Case Officer: Saffron Loasby

Recommendation: Approve

Proposal: Changes proposed to the landscaping details, to replace the timber knee rail around the area of 'EM2 Standard General-Purpose Meadow Mixture' with a 1.0m high stock-proof timber post and rail fence, along the eastern edge of the development (proposed as non-material amendment to 19/00963/OUT)

scheme: Land off Berry Hill Road,
Alderbury, Banbury
client: Hayfield Homes
drawing: Landscape Proposals
date: March 2022
scale: 1:200@A1
drawing no: HAY23648-11H Sheet 3 of 3
drawn: SR checked: JC

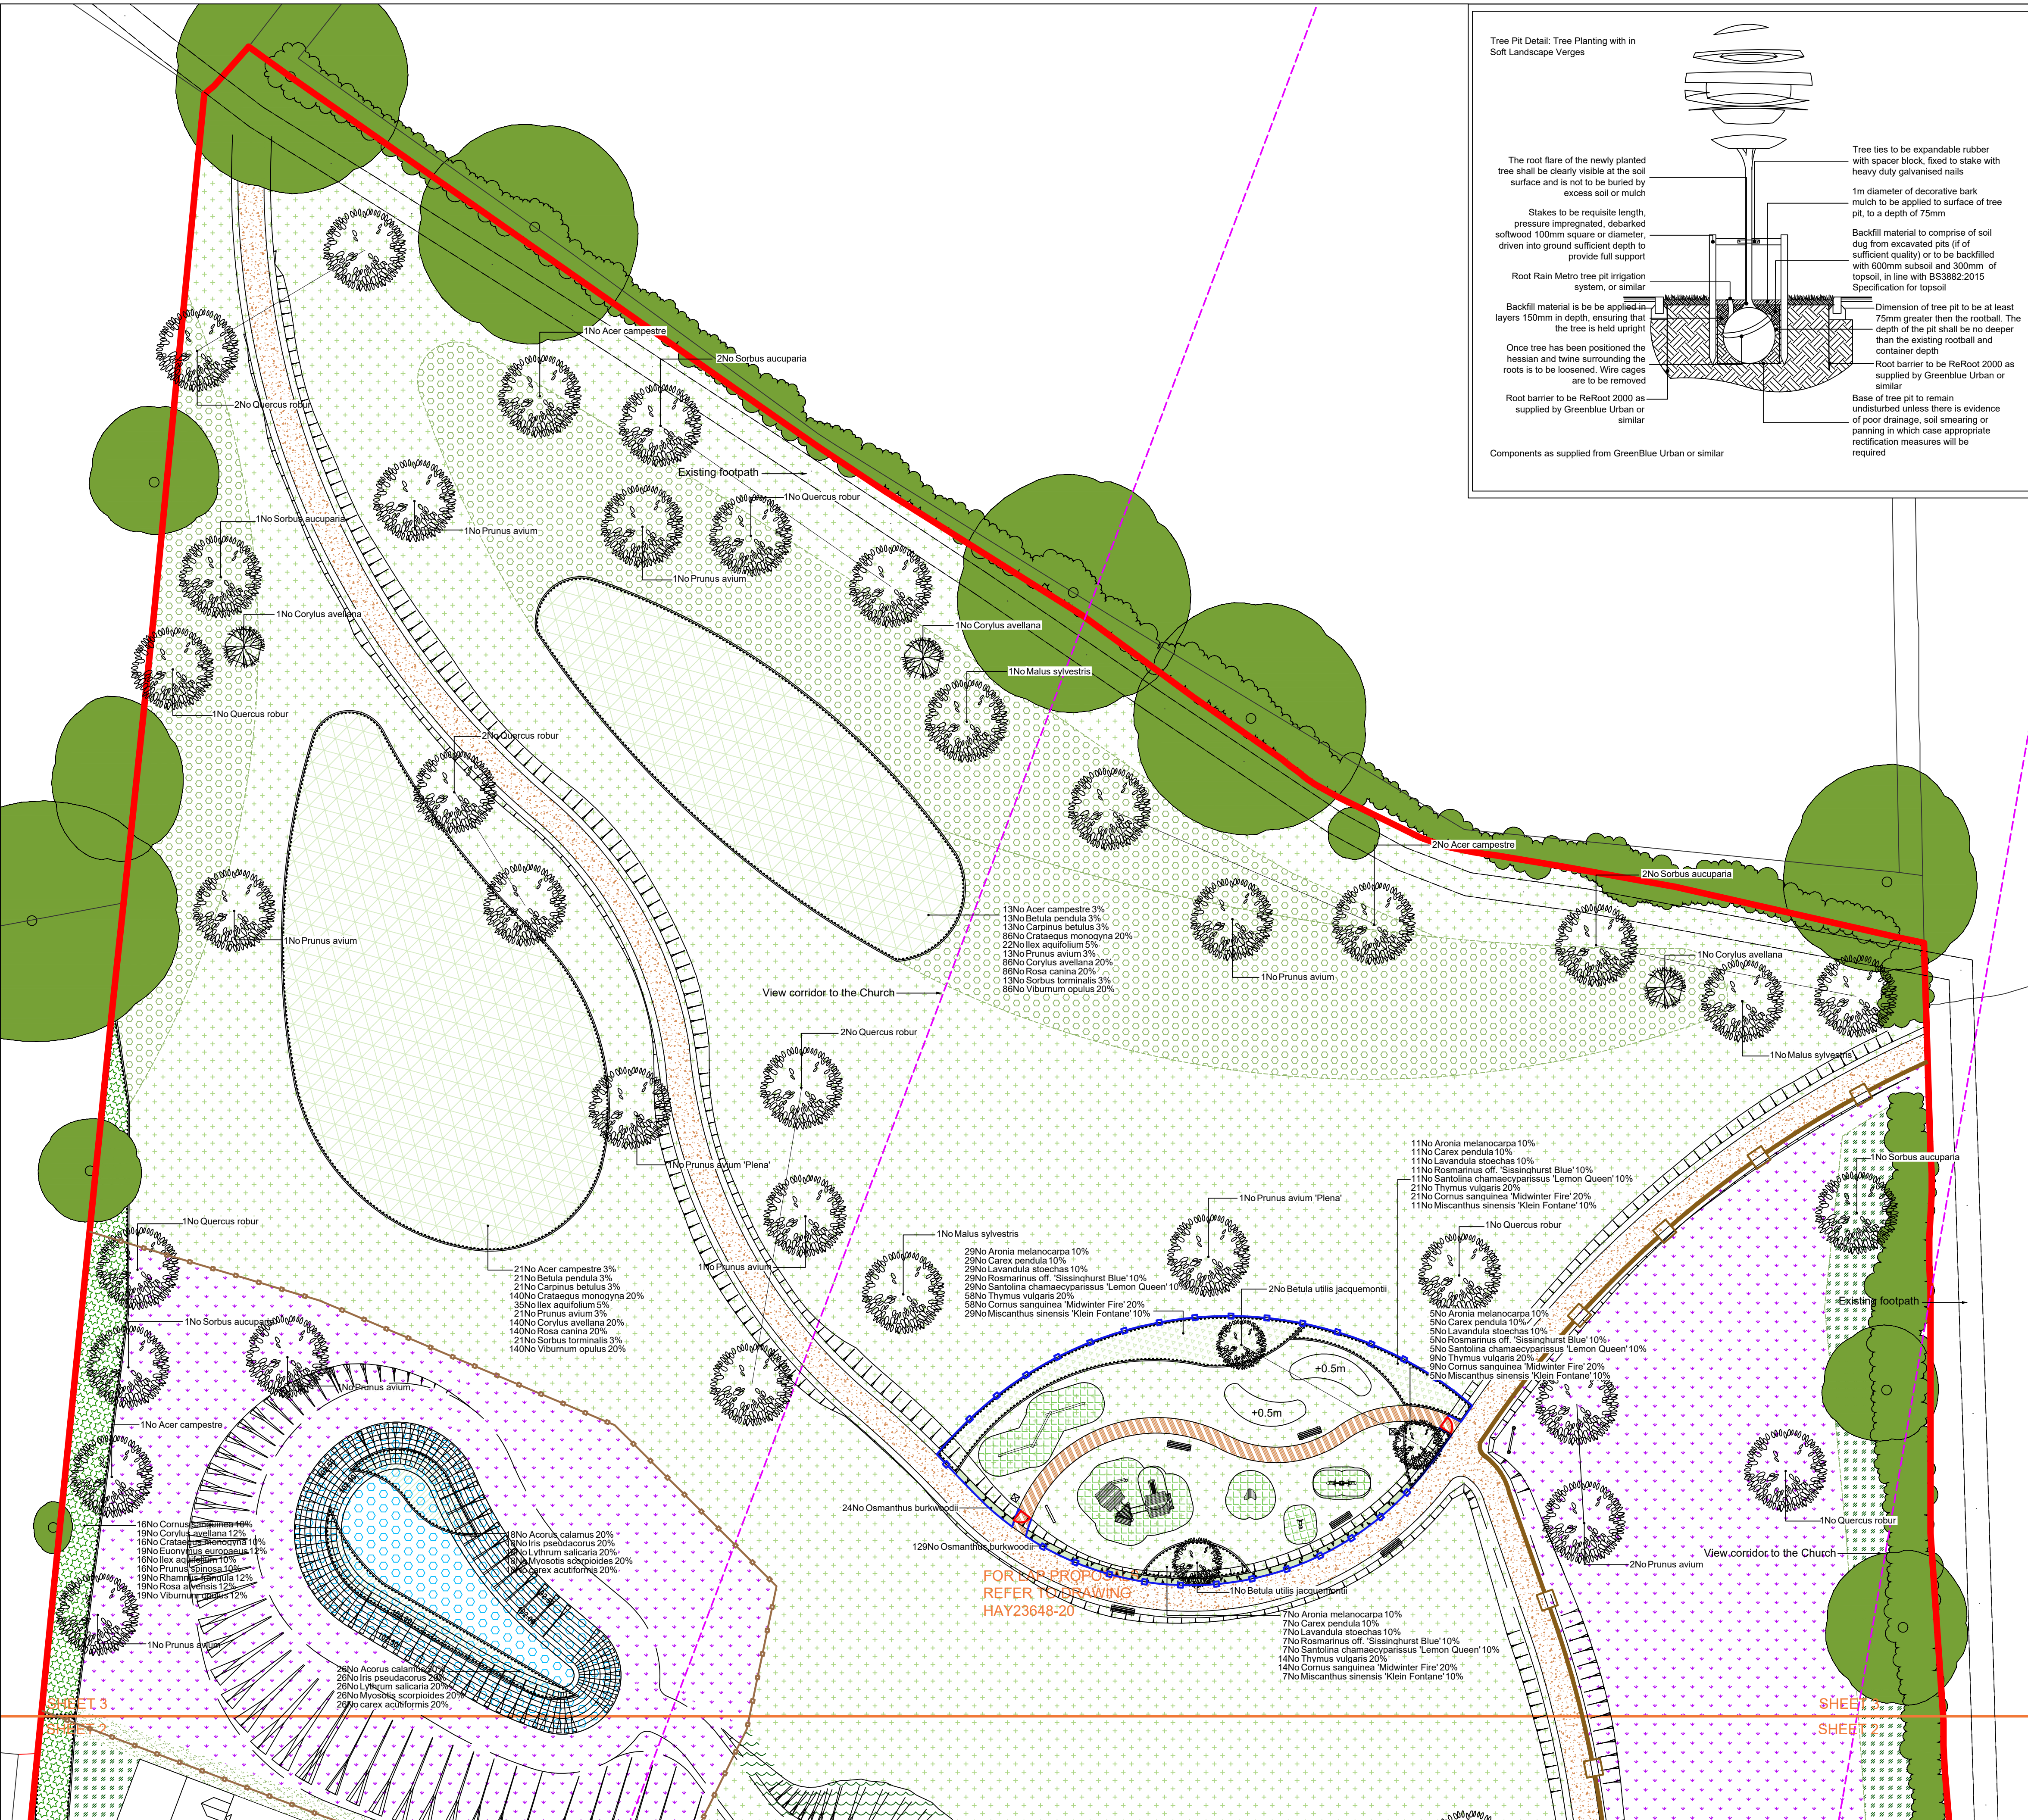
5.3. The scheme already benefits from an approved timber knee rail around the revised areas of EM2 General Purpose Meadow Mixture across the site. This non-material amendment sees the knee rail replaced with a 1m high stock proof timber post and rail fence.

5.4. The new fencing would complement the existing approved scheme and assist in continuing to protect the biodiversity enhancements across the site. The change would not raise any new issues and does not contradict previous agreements or amendments. All the proposed changes are within the site as defined by the site edged red.
